EL PASO COUNTY GRADING AND EROSION CONTROL PLAN CHECKLIST

EPC Project Number:

BMP PHASING

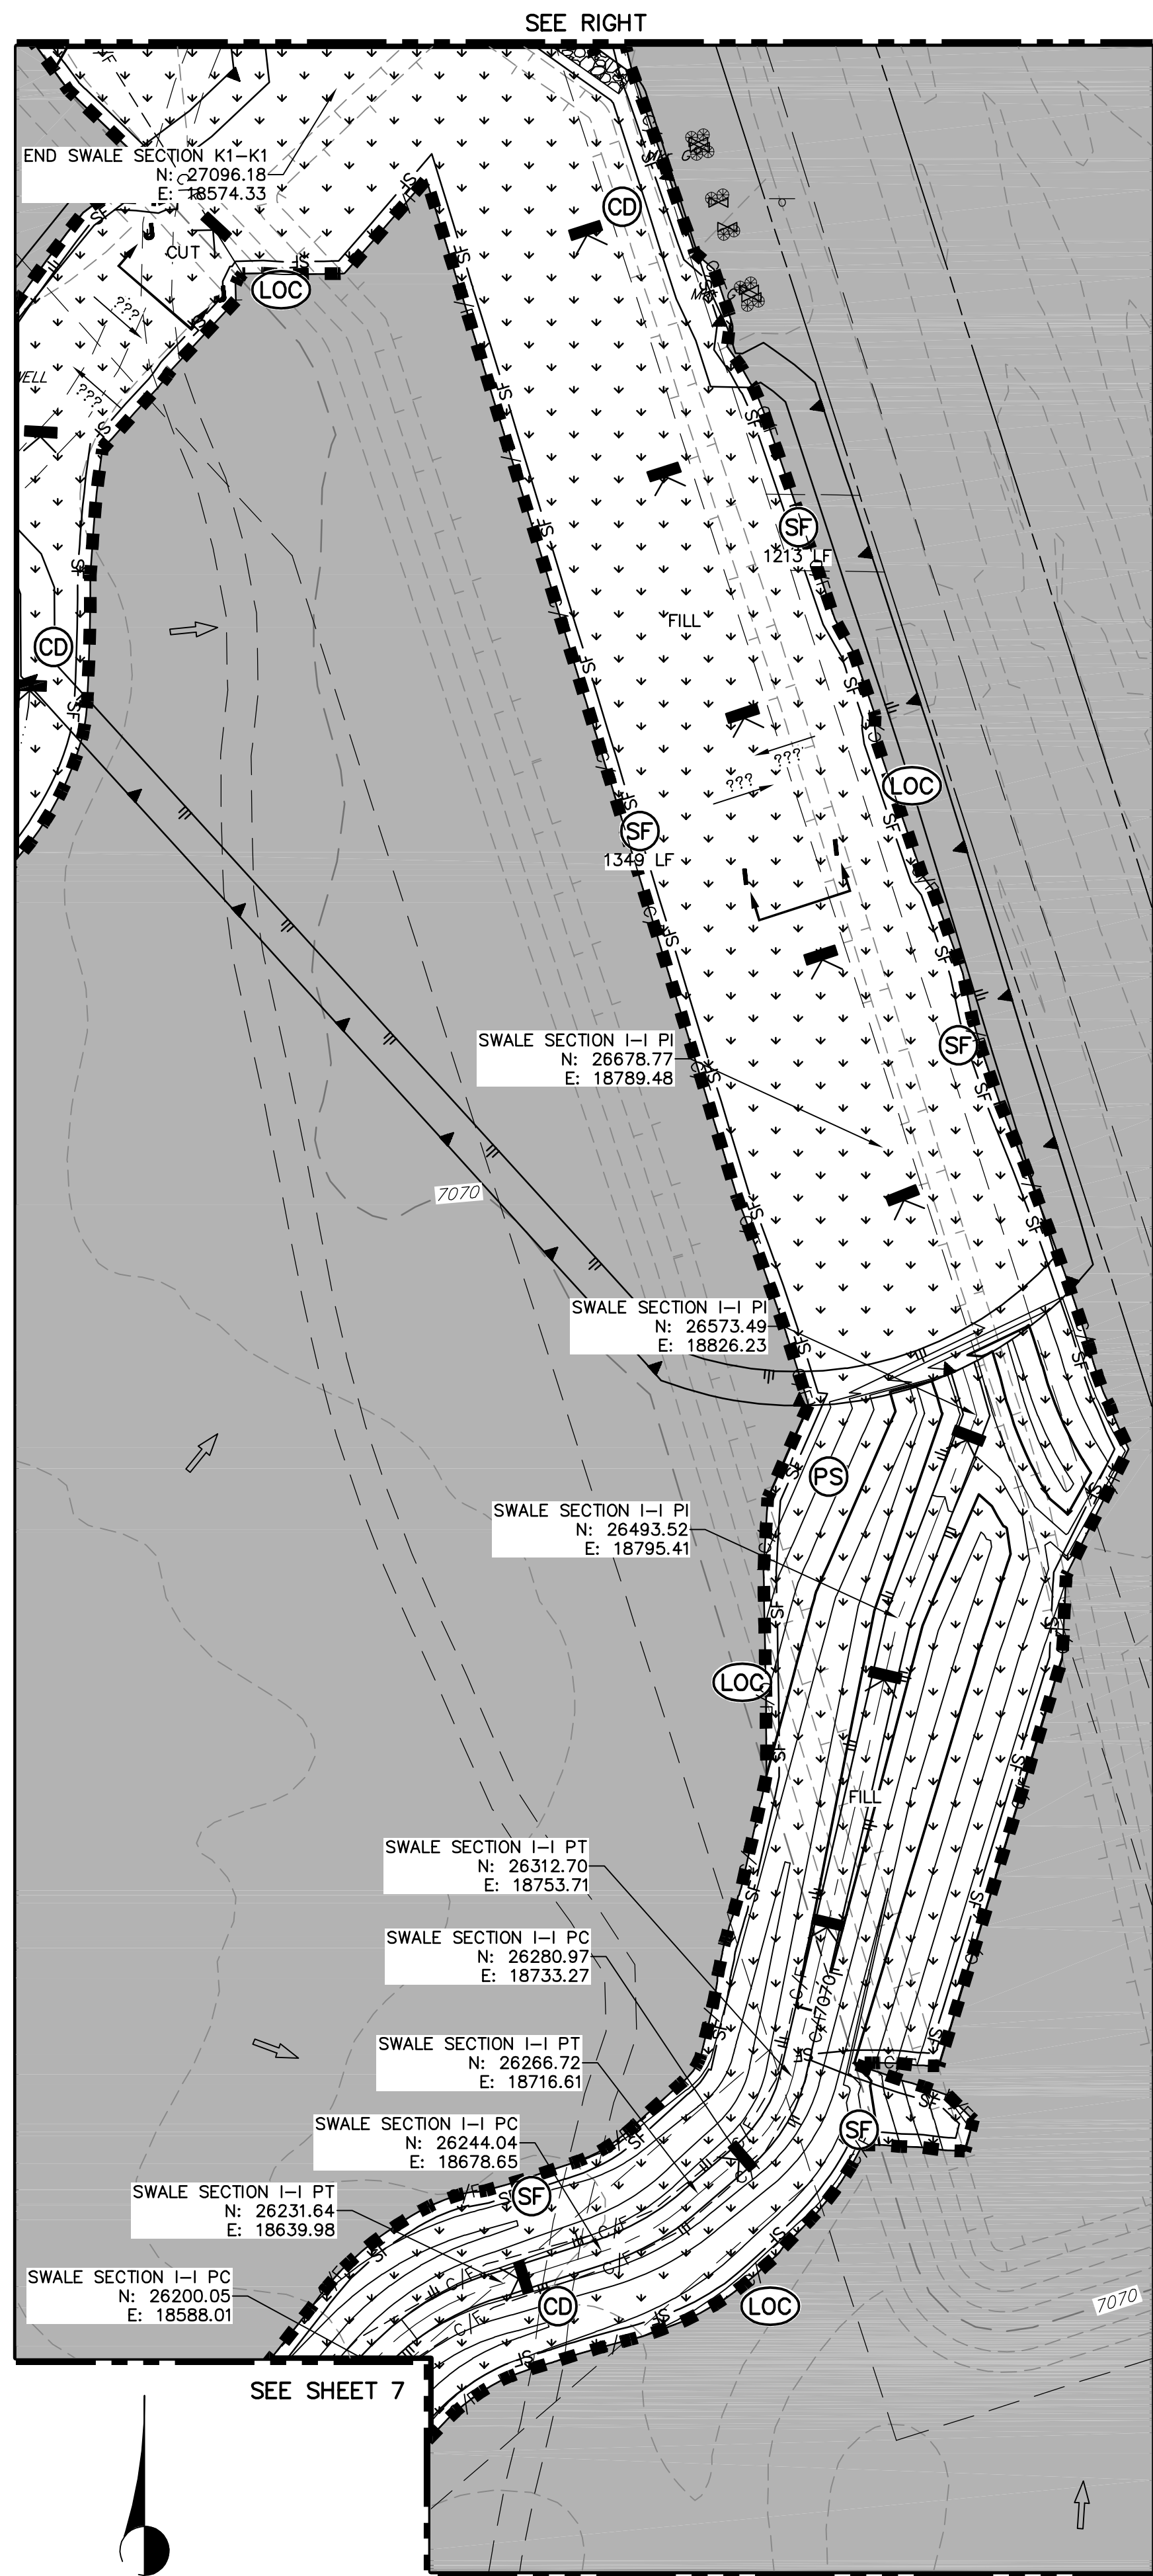
Please review outfall of all ditches and swales to make sure that all tributary areas >1ac are being conveyed to a TSP.
